SECTION 73 OF THE TOWN AND COUNTRY PLANNING ACT 1990 (AS AMENDED) AMENDMENT APPLICATION PURSUANT TO PLANNING PERMISSION 22/02168/FUL AT PLOTS 23-26, OXFORD SCIENCE PARK, GRENOBLE ROAD, OX4 4GE.

I am instructed by The Oxford Science Park (Properties) Limited ('the Applicant'), to submit an application under Section 73 of the Town and Country Planning Act 1990 (as amended) to vary Condition 2 (Approved Drawings), Condition 14 (Landscaping Plans), Condition 20 (Underground Services – Tree Roots) and Condition 35 (Swept Path Analysis) pursuant to planning application ref: 22/02168/FUL.

2 LEVELS AND 1 LEVEL UNDERCROFT COMPARISON WITH WATER TABLE

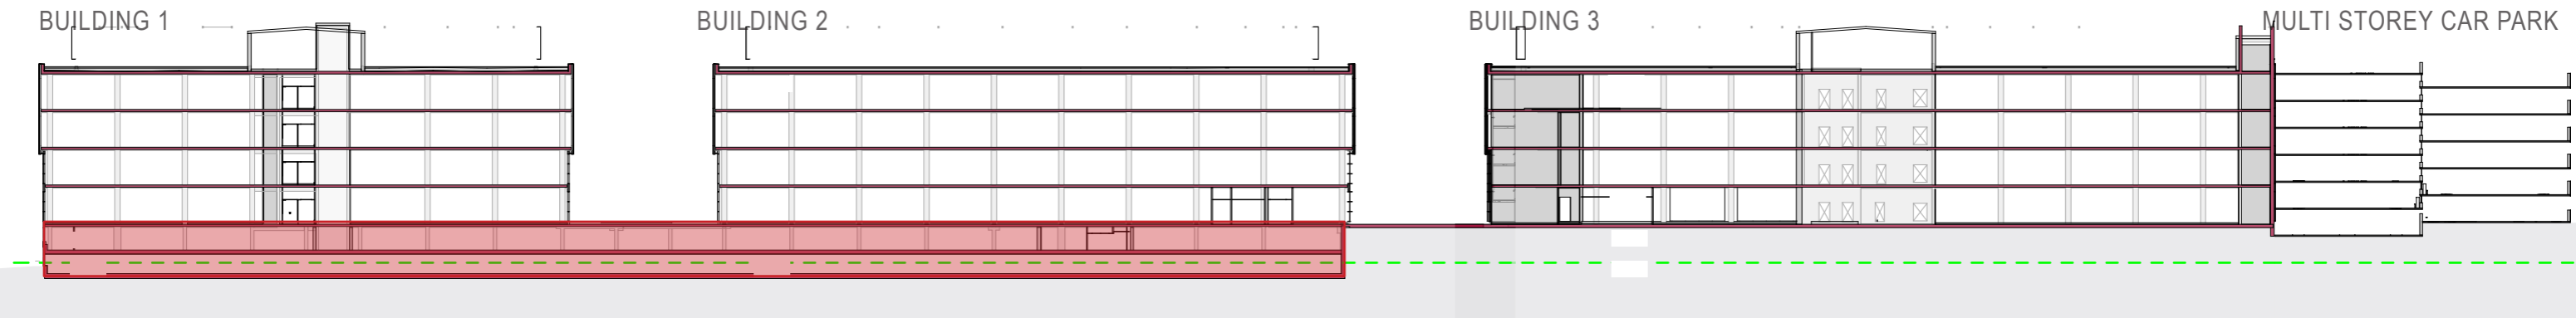
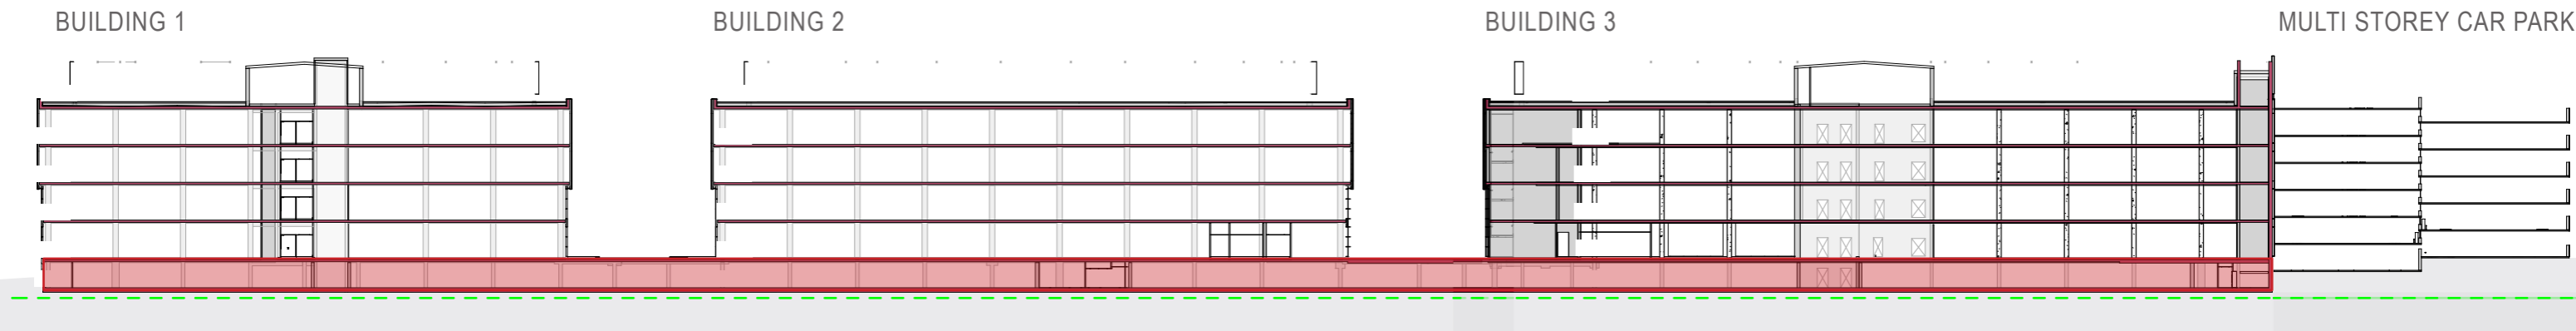
The change to the design is a response to detailed analysis of groundwater levels of the site. Water level surveys have shown that the water table levels are higher than was understood at the planning application stage. It has become clear that the consented design requires a water abstraction licence from the Environment Agency. This process could take circa 12 months, which would create an unacceptable delay. As a result, it is proposed to remove level -2 and extend level -1 under all three buildings, rather than solely Buildings 1 and 2 as previously approved. The single storey undercroft will reduce depth of excavation, improve buildability and reduce the impact on flooding, which are considered to be acceptable and overall to improve the scheme. It is considered this accords with Policy RE3 (Flood Risk Management) which states proposed development should not increase flood risk on site or off site

BUILDING 1, 2 & 3 PROPOSED UNDERCROFT PLAN

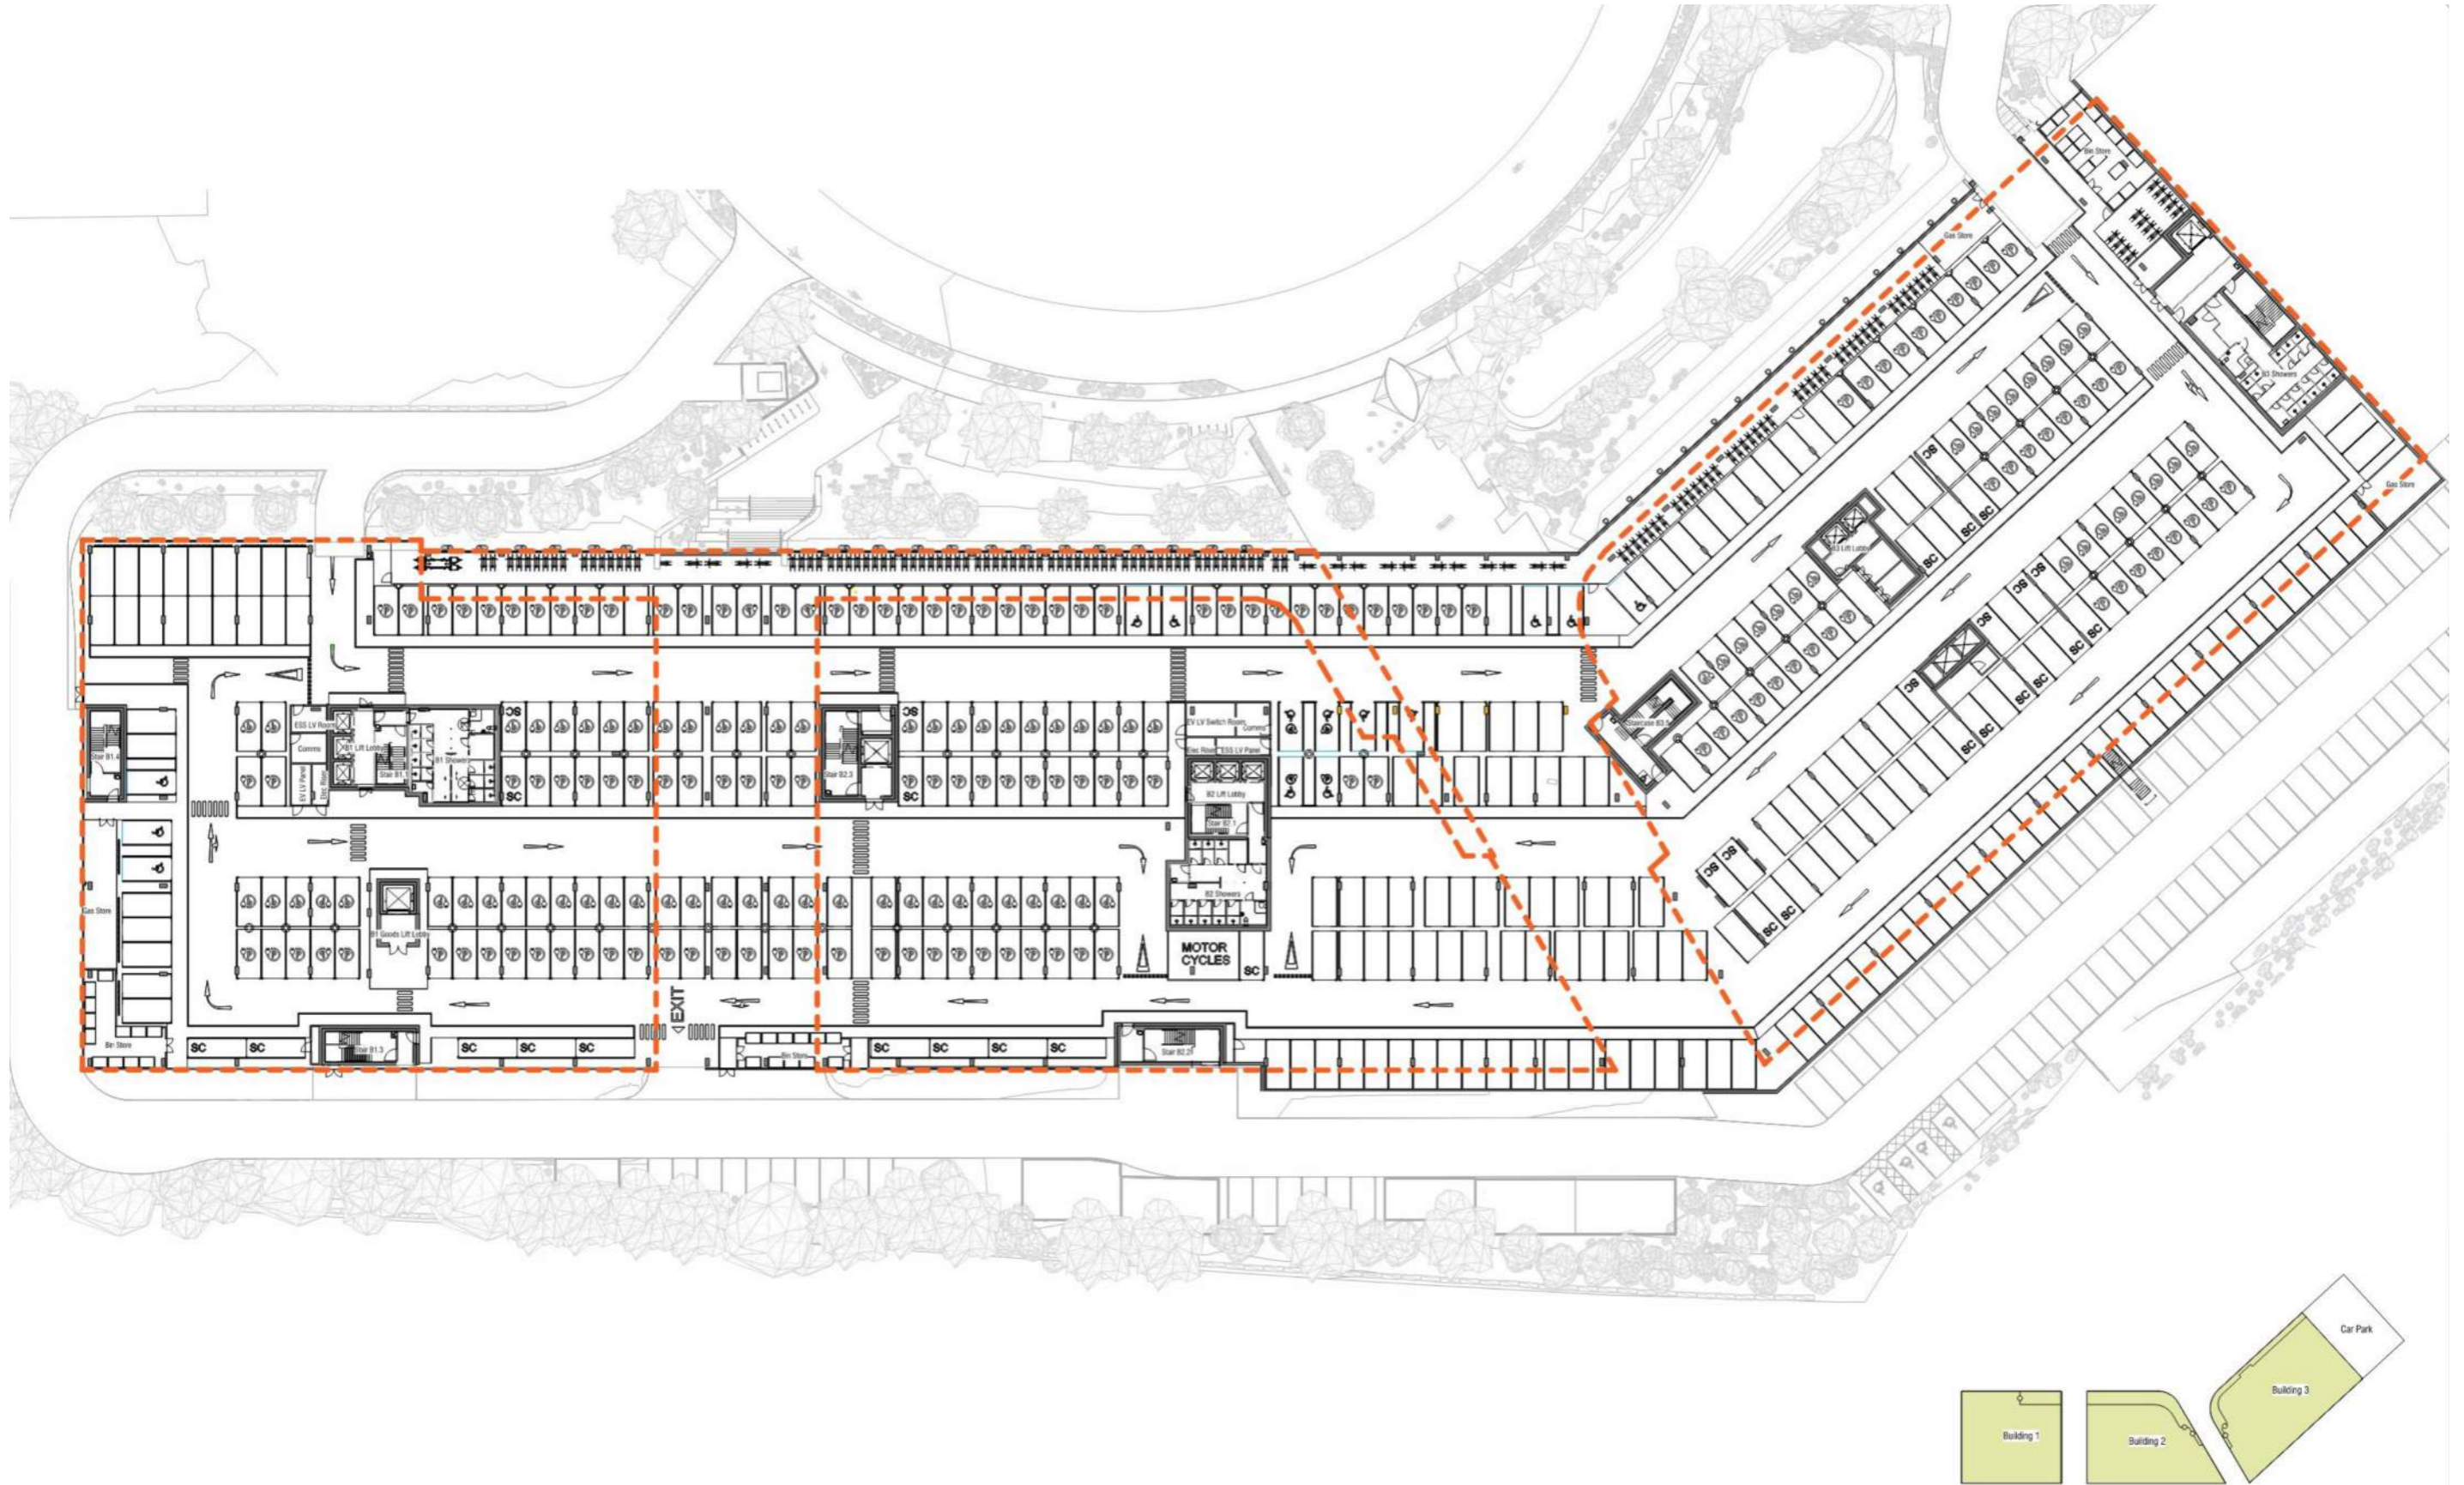
Item	Description of Change
Single Storey Undercroft	The removal of Level -2 undercroft and extension of Level -1 under Buildings 1, 2 and 3.
Amended shower block in Building 3	Building 3 shower block relocated from ground floor level to Level -1. This change is internal to the building and does not require planning consent, but is included to demonstrate there is no loss of shower provision for cyclists.
Amended Landscaping	Minor changes to approved landscaping to enable a ramped access to Level -1 under Building 3
Reduced Car Parking Numbers	Reduction in total car-parking provision from 892 car parking spaces to 861 car parking spaces. There is no change to cycle numbers.

The new undercroft design changes vehicle circulation and a new ramp is proposed to provide access from ground level to level -1 below Building 3. Swept path analysis drawings have been submitted under application ref: 23/02168/CND to discharge condition 35 (Swept Path Analysis). At the time of writing this letter, the swept path analysis drawings have been assessed as acceptable, informally discharged and a formal decision notice has yet to be issued. Revised swept path analysis drawings have been submitted under this application to reflect the revised undercroft layout and supersede the drawings previously submitted to the Council. These drawings are listed in the table earlier in this letter.

BUILDING 3 APPROVED VS PROPOSED GROUND FLOOR PLAN

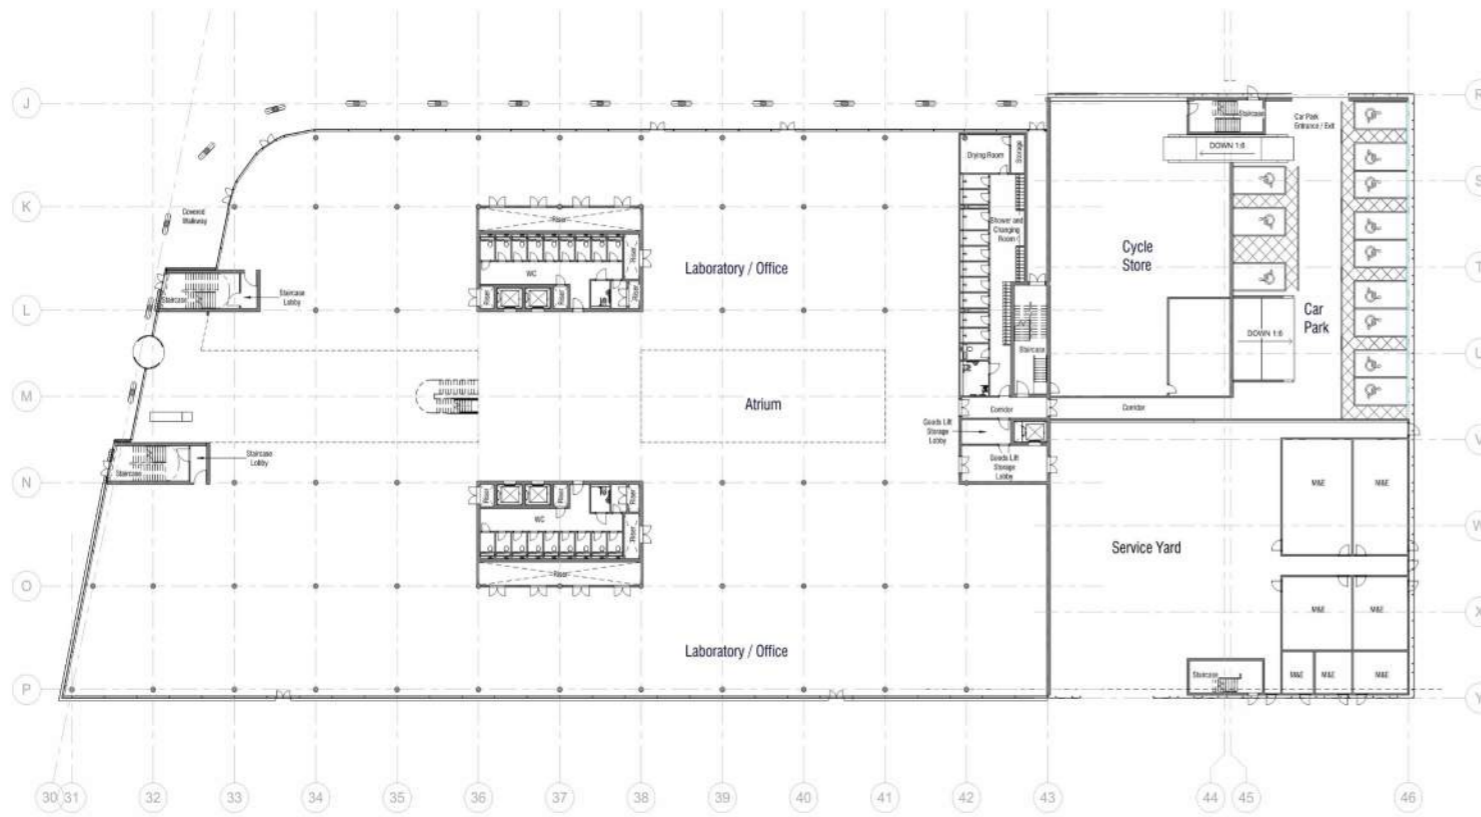
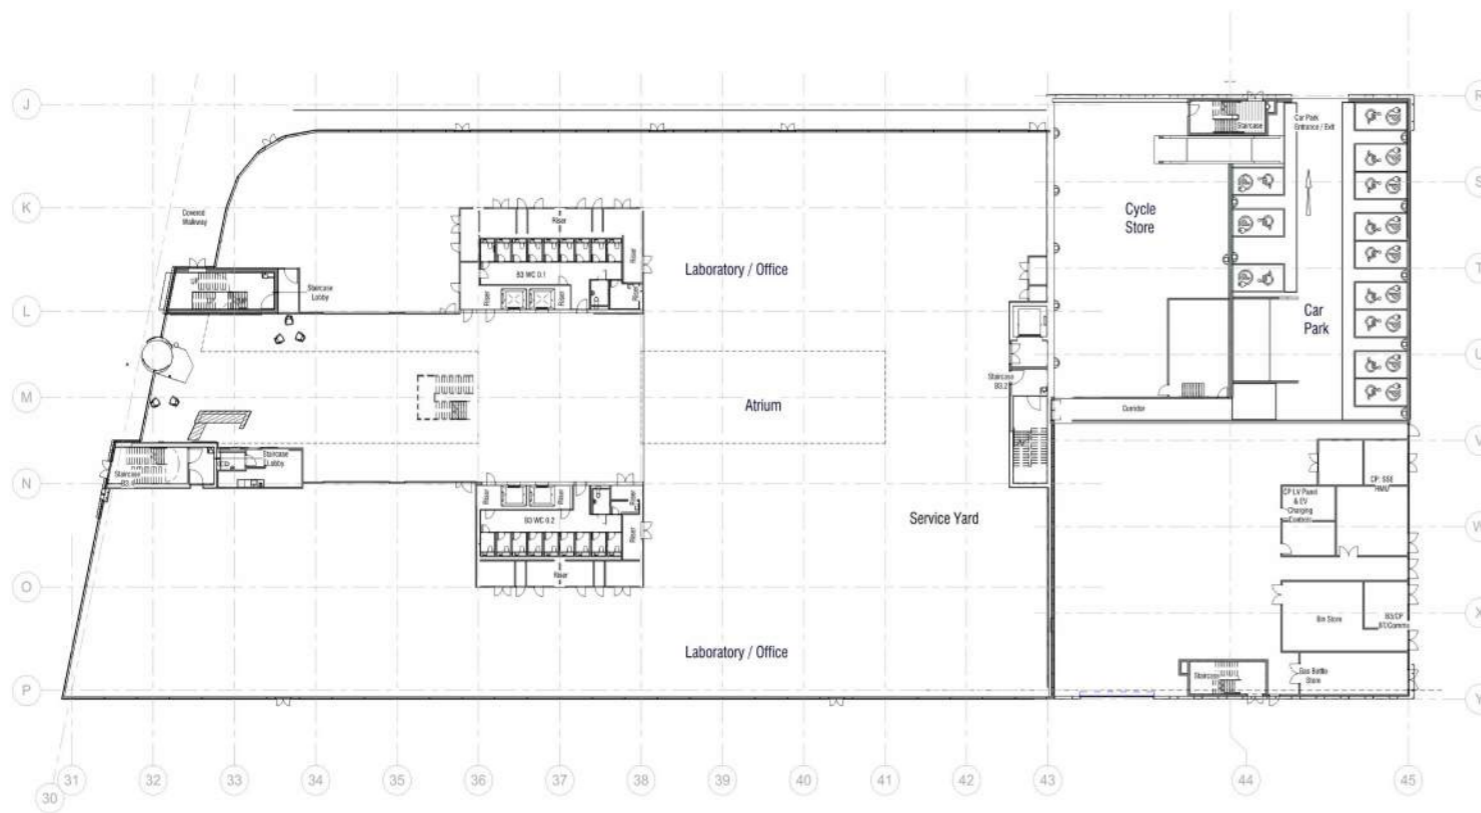
There are no proposed changes to the building design above ground level, other than consequential changes to the landscape arising from the creation of a new egress point below Building 3. The new access ramp to level -1 under Building 3 has resulted in minor changes to landscaping surrounding this new ramp. It is considered that this change is minor in the context of the wider landscaping scheme
